Updated Response to Traffic Matters raised in TfNSW Letter (dated 7/09/21)	
Matter Raised	Response
The network model shows inconsistent cycle times for each intersection. A 120 second cycle time should be used in the network model.	The SIDRA network model has been updated with a cycle time of 120 seconds used for all scenarios. An updated summary table of the SIDRA results is attached.
The network model should consider a scenario where the Rooty Hill Road South/Church Street intersection is not signalised (e.g. left-in/left-out), for the intersections that have been modelled.	A scenario where the intersection of Church Street/RHRS is not signalised (and turning movements are limited to left in/left out) has been analysed. The results are presented in the attached table. This results in additional right turning traffic at the intersection of Rooty Hill Road South (RHRS)/Goldsbro Glade, with the LOS reducing from B to C and the right turn bay on RHRS into Goldsbro Glade overflowing. We note that Council support the proposed traffic signals at the intersection of Church Street/RHRS (improves access to the existing playing fields) and that limiting turning movements to LI/LO would rest

INTERSECTION LAYOUT - CONCEPT LINEMARKING PLAN
SCALE: 1:250 @A1

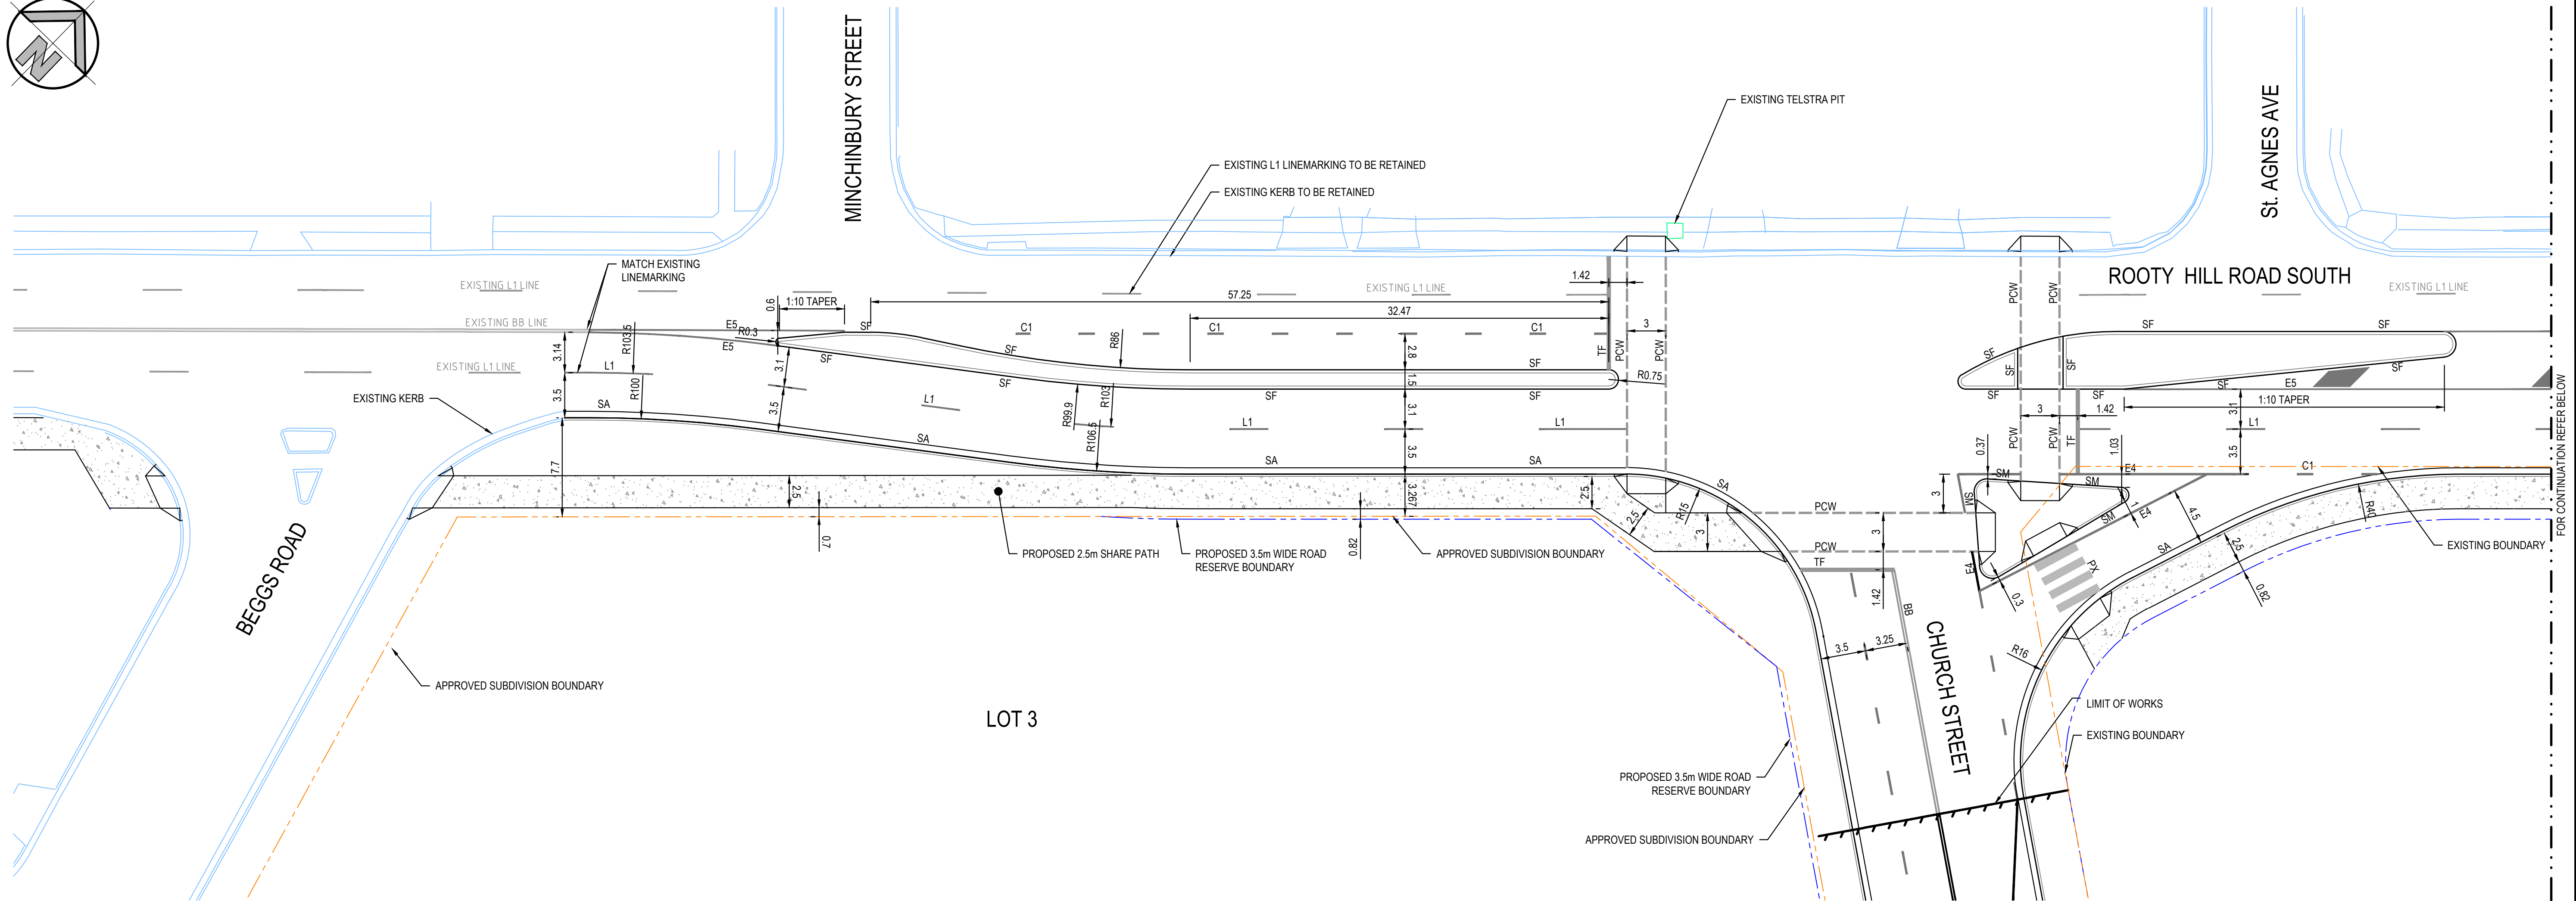
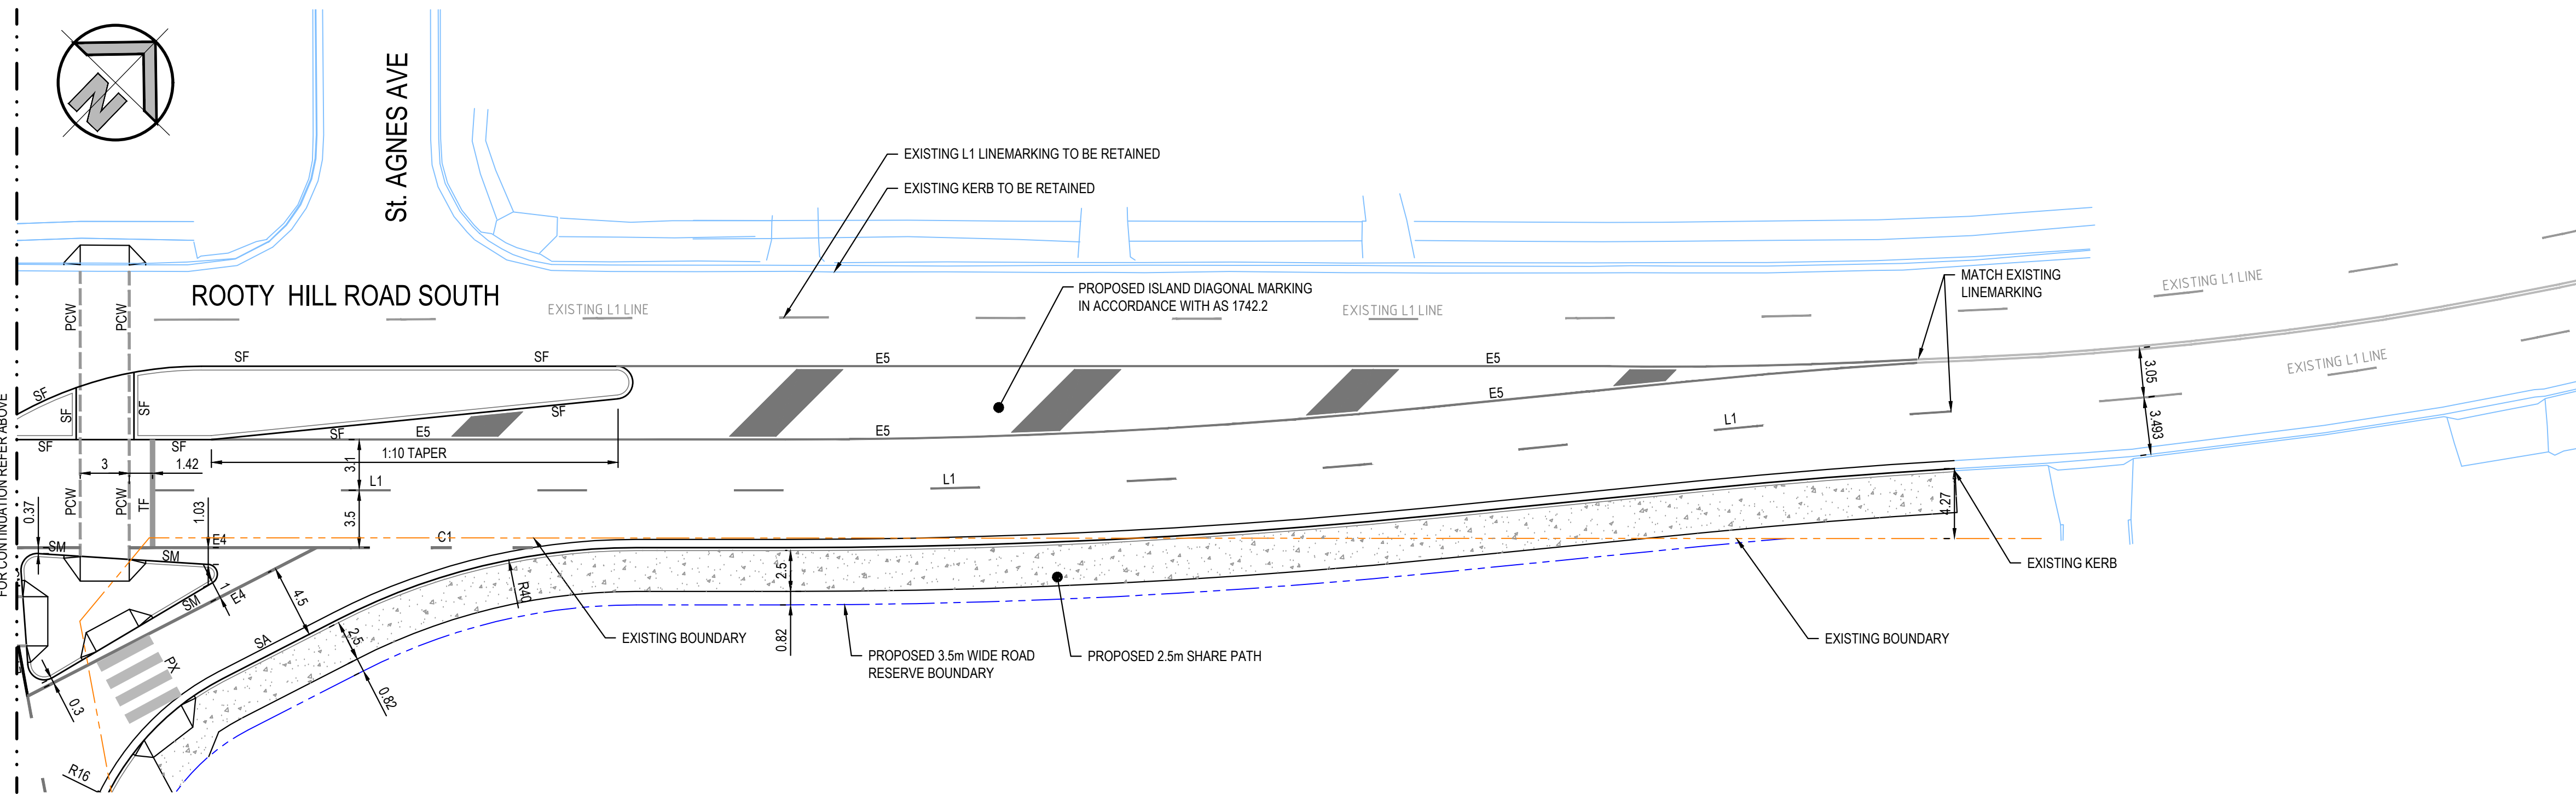
<p>It is understood that a left turn deceleration lane cannot be achieved at the Rooty Hill Road South/Church Street intersection due to environmental/historical artefact concerns. The submitted concept plan for the new traffic control signals at this intersection shows a lane being provided on this land and the need for tree removal. Confirmation is requested regarding the extent of the proposed civil works associated with the proposed traffic control signals on the land with environmental/historical artefact issues.</p>	<p>The attached plans show that provision of a separate left turn deceleration lane has a greater impact on the sensitive environmental/heritage areas on the NE corner of the intersection of RHRS/Church Street</p> <p>The area of land on the north east corner of the RHRS/Church Street intersection is environmentally sensitive and is part of the State Heritage Listing. In relation to the environmental impacts, the Environment Protection Biodiversity Conservation Act (EPBC Act) requires that proposed impacts be minimised. Likewise, the Heritage Act requires that proposed impacts in the item be minimised. The proposed traffic signals at the RHRS/Church Street intersection (without a separate left turn deceleration lane) provide an appropriate traffic outcome that minimises the environmental and heritage impacts on the land on the north east corner of the intersection.</p> <p>As per our discussion on 21/10/21 – a high angle left turn slip lane has been provided from RHRS into Church Street</p>

<p>The Rooty Hill Road South/St Agnes Avenue intersection would need to have a left-in/ left-out treatment.</p>	<p>As per our discussion on 21/10/21, the intersection of RHRS/St Agnes Avenue has been made LI/LO. Existing right turning traffic is low (at some 5 to 10 vehicles per hour in the PM peak hour). Alternate access to St Agnes Avenue from the north is available via Church Street, with a turning head provided just to east of the playing field access).</p>
<p>The proposed staged pedestrian crossing is not supported at the Rooty Hill Road South/Church Street intersection location.</p>	<p>As per our discussion on 21/10/21, the staged crossing has been replaced by a single crossing. The SIDRA has modelling is based on a single crossing.</p>
